**7000 Acres**

**7000 Acres Response to the Cottam Solar Project Ltd Application on the subject of:**

**Inaccuracies in the Book of Reference**

**Deadline 1 Submission – 17<sup>th</sup> October 2023**

Land Plans - Onshore
 Sheet 10 of 19

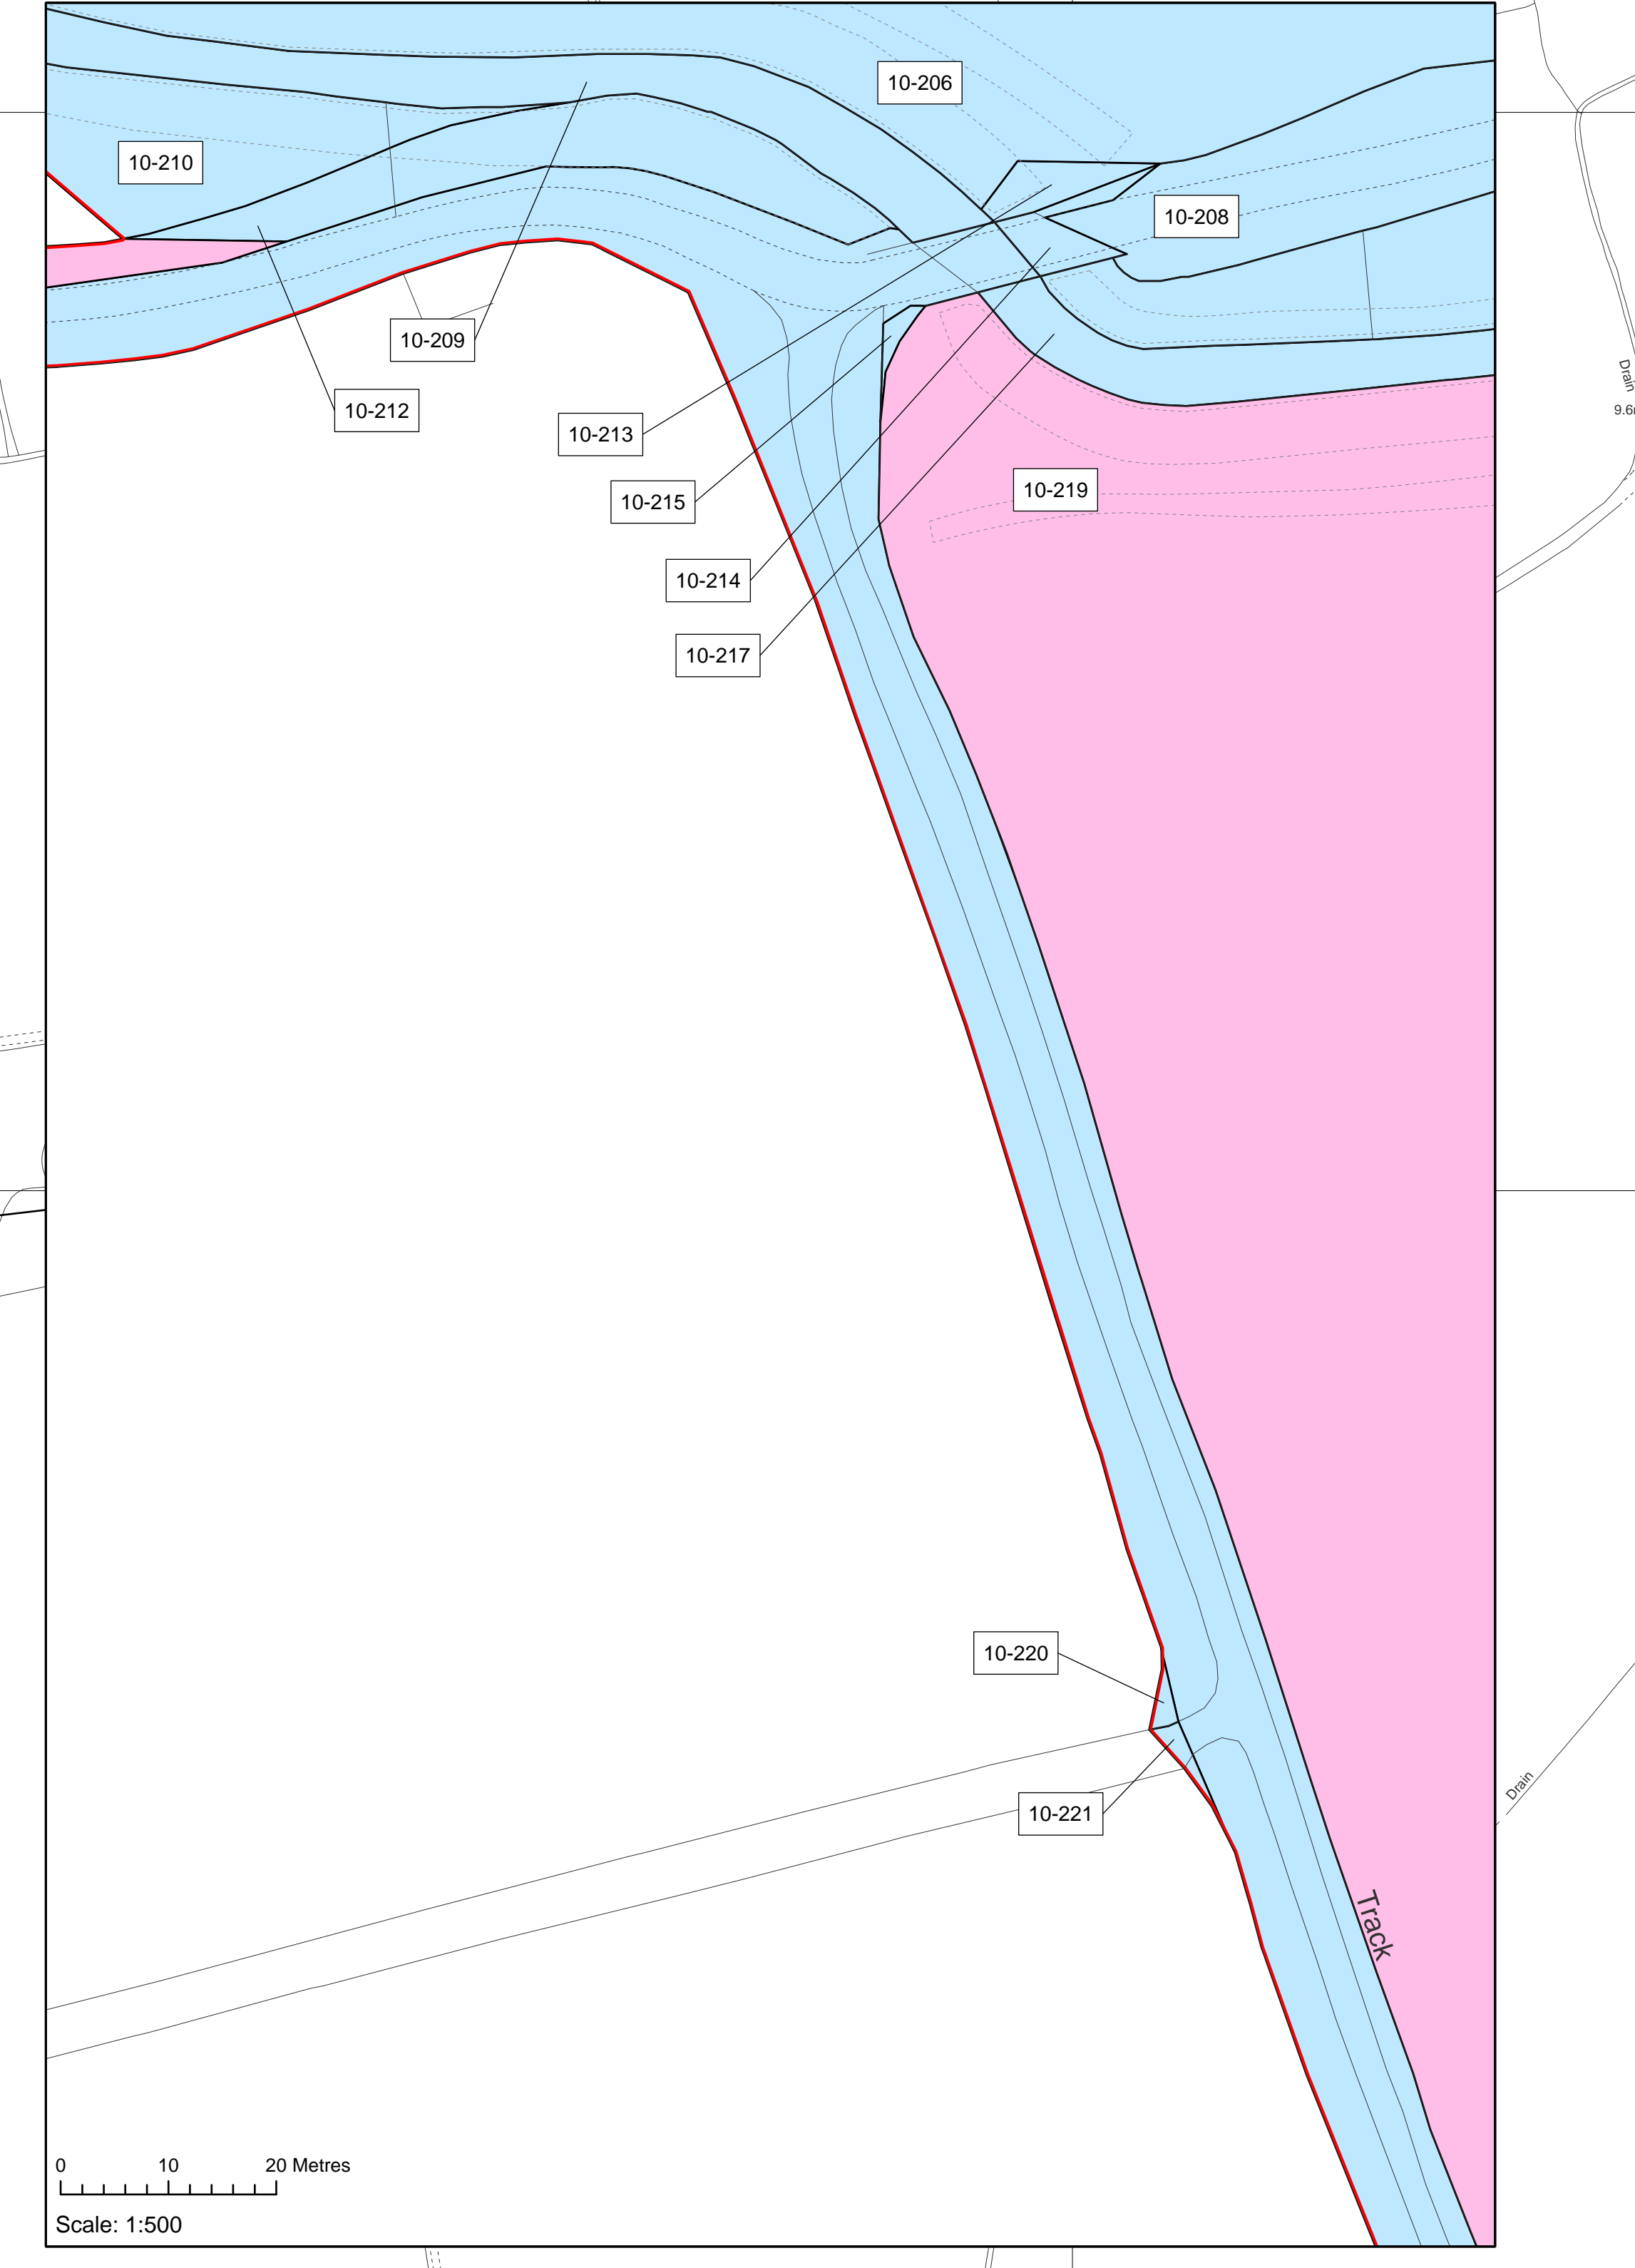
Sampling of the Land Registry has identified that for plot 10-241 the ownership is recorded in the Book of Reference as being Tillside Limited whilst the Land Registry shows ownership as being Kevin Simon Webster, James Charles Stewart Reynolds Milligan-Manby and John Anthony Shepherdson as trustees of the C Nicholson No1 Settlement. This inconsistency questions the validity of the data published within the Book of Reference for the other 82 entries of Tillside and this document needs to be carefully reviewed, corrected and resubmitted.

Land Plans - Onshore
 Sheet 11 of 19

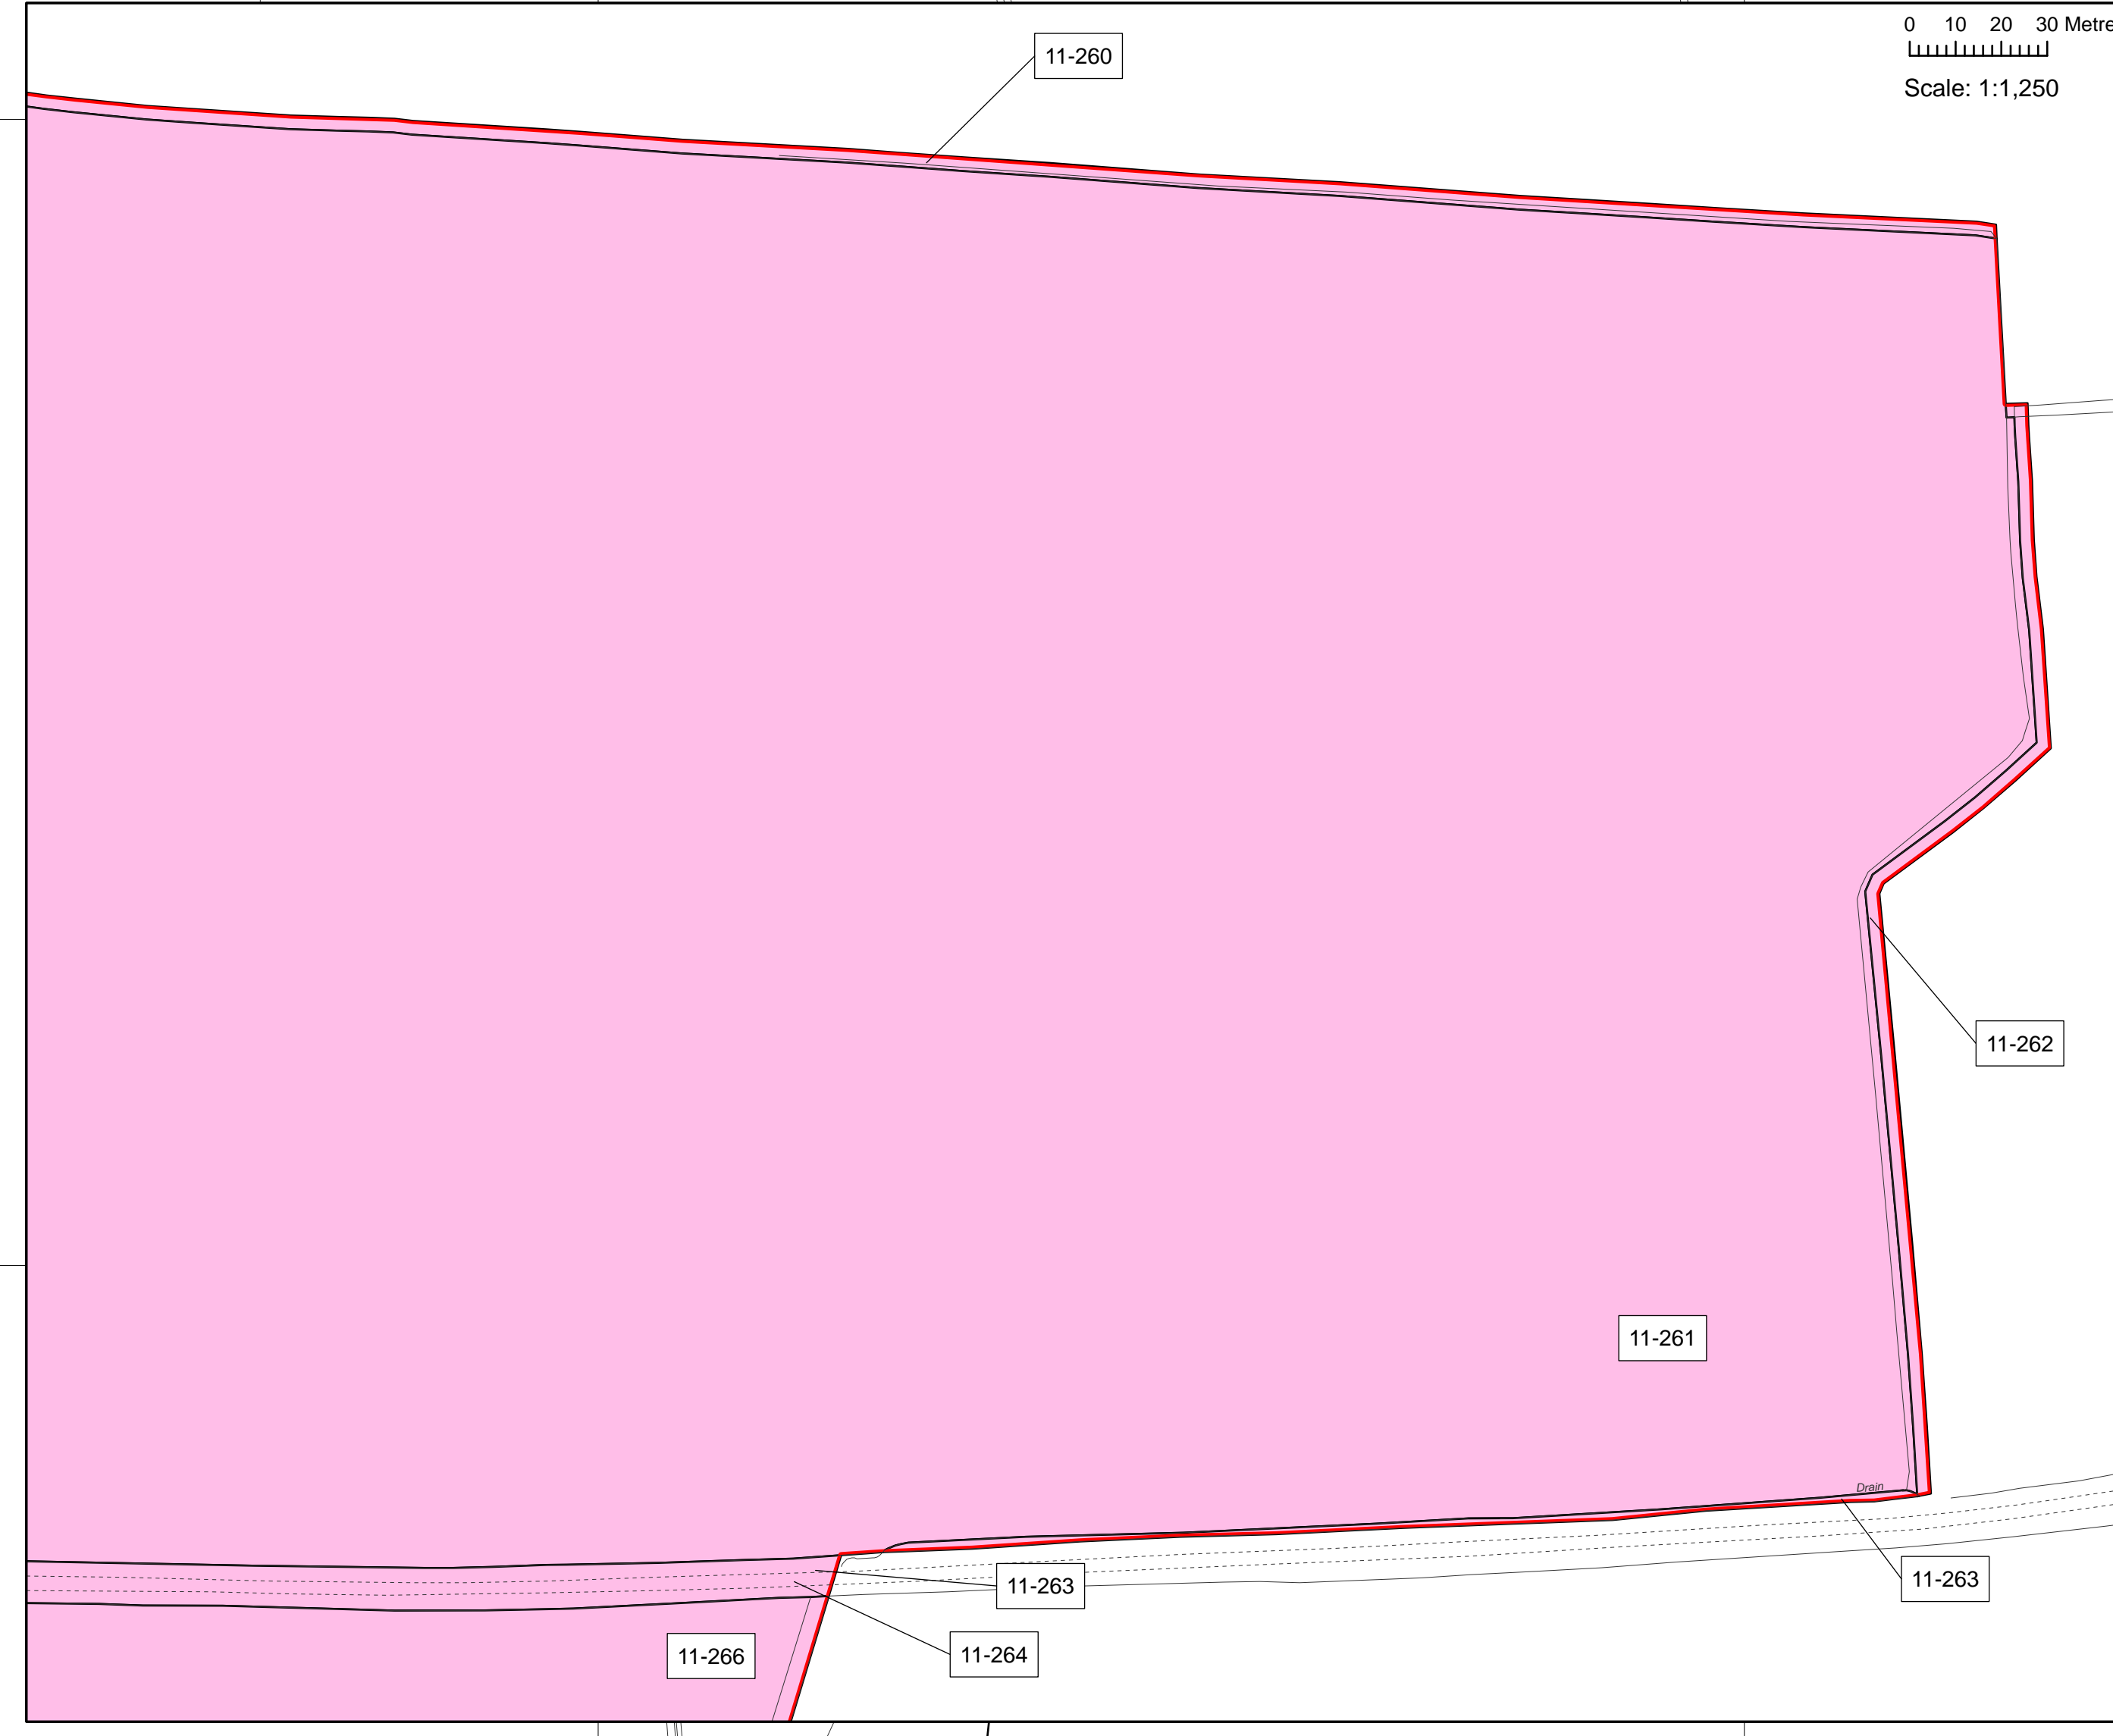
Entry 11-263 Is incorrectly identified in the Book of Reference. (as beneficiary of an Option Agreement dated 19th February 2021)

Entry 11-265 Is incorrectly identified in the Book of Reference. (as beneficiary of an Option Agreement dated 19th February 2021)
